Application No: CM/18/25/DOC
Site Address: Land West of Church Lane & South of Horsemere Green Lane Climping
Description of works: Approval of details reserved by condition imposed under reference CM/1/17/OUT relating to condition number 9 - i. surface water drainage scheme and ii. a foul water drainage scheme and condition number 10 - i./ ii. watercourses and iii. rising main and foul sewer pipe.

Thank you for your internet representation made on 21st May 2025 which has been recorded as an objection with the comments as follows:

Drawing Title
**Drainage Long Sections
Foul Water Rising Main**

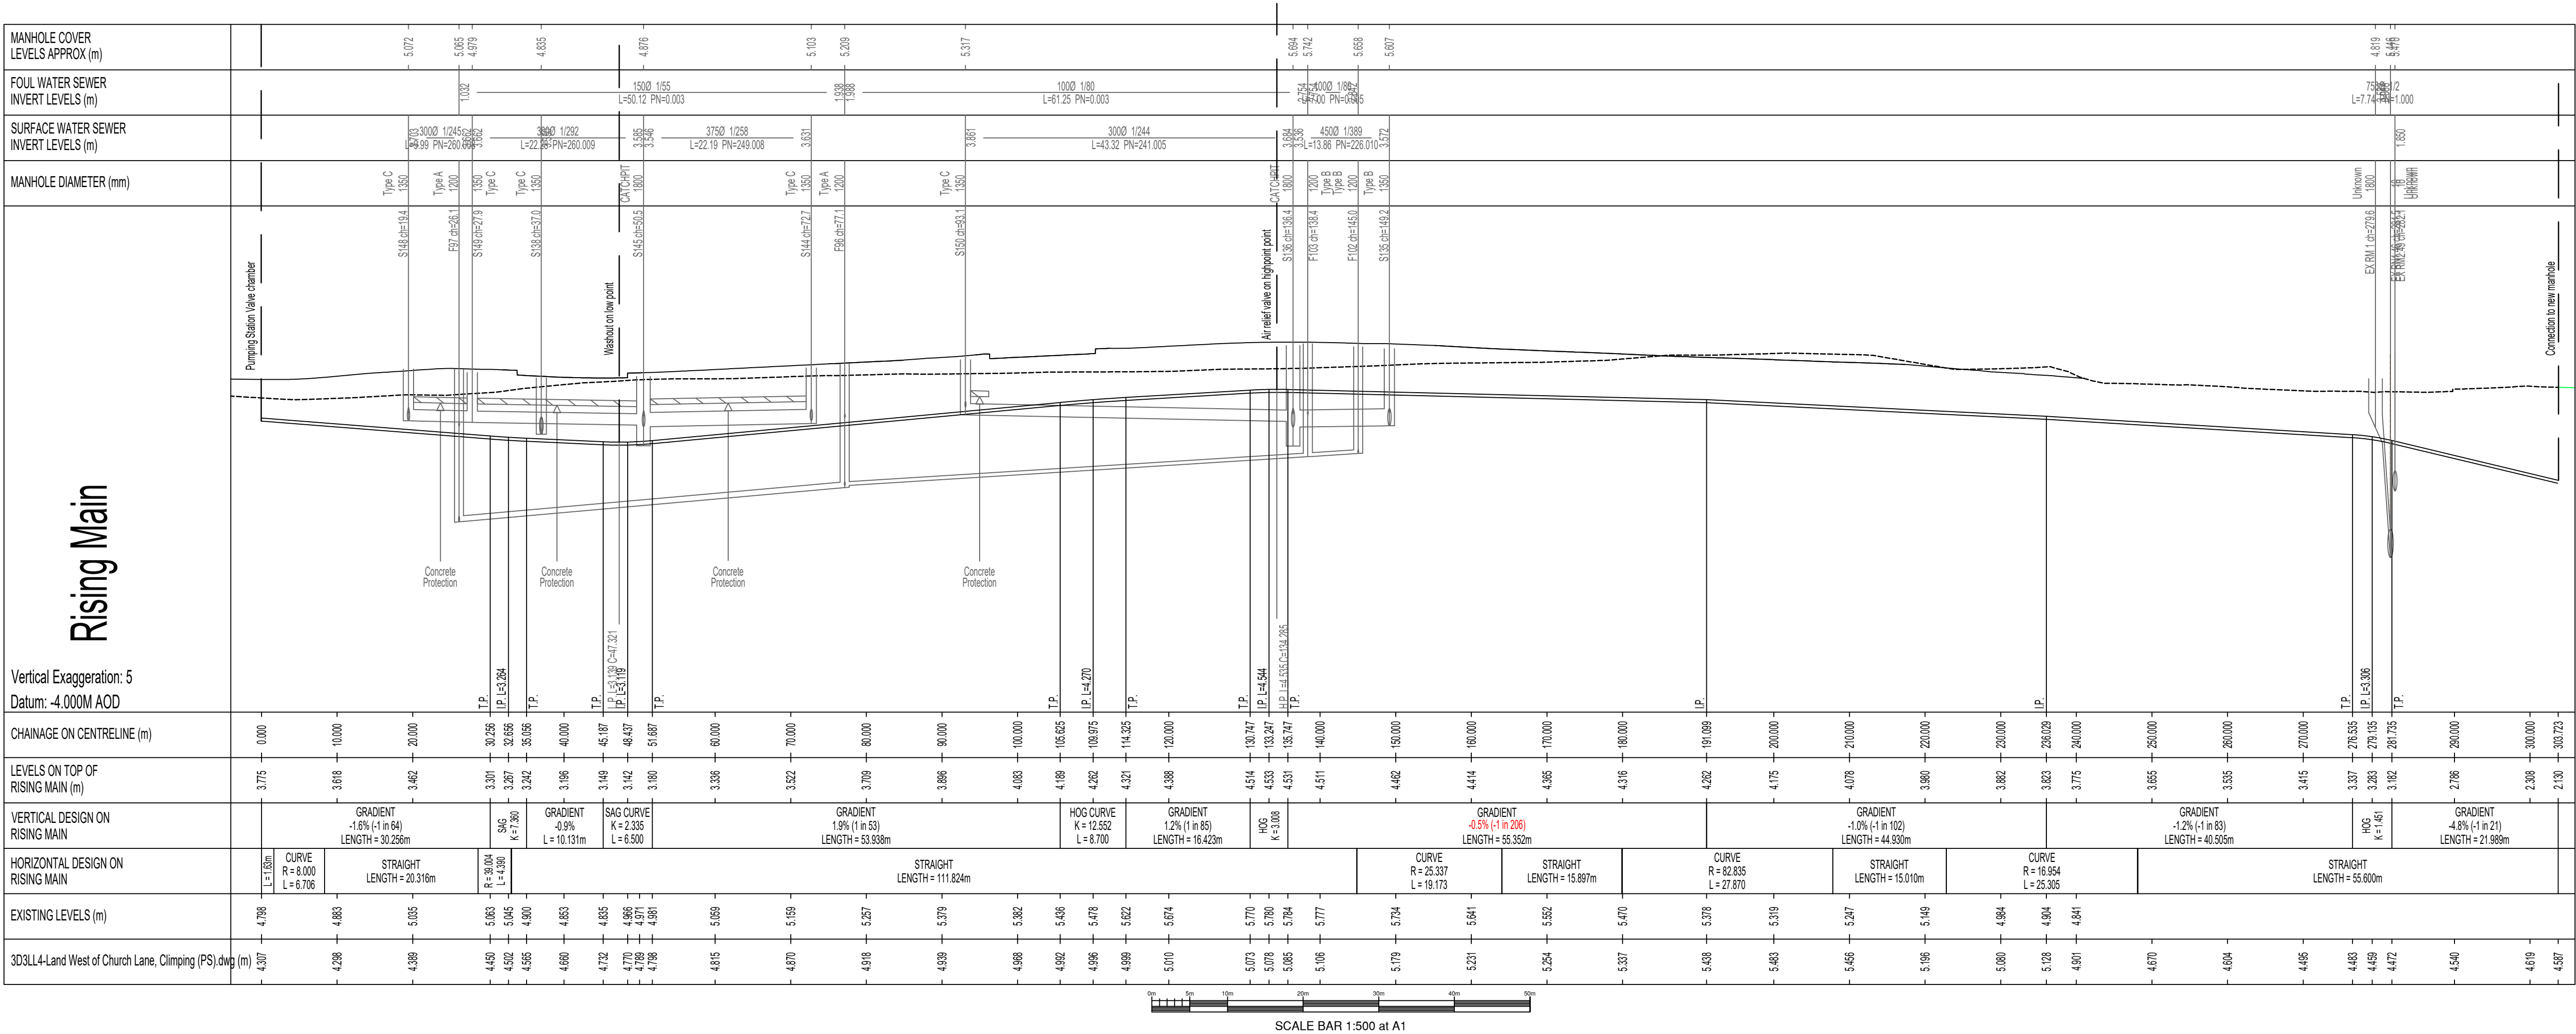
5. A particular concern is the high pressure sewer that crosses the site en route from Littlehampton to Ford. The construction Management Plane should be explicit with regards the steps that will be taken to ensure this sewer is not damaged during the construction phase. The PC is acutely aware of the recent failure of the similar Felpham to Ford sewer to the west of Yapton Road.
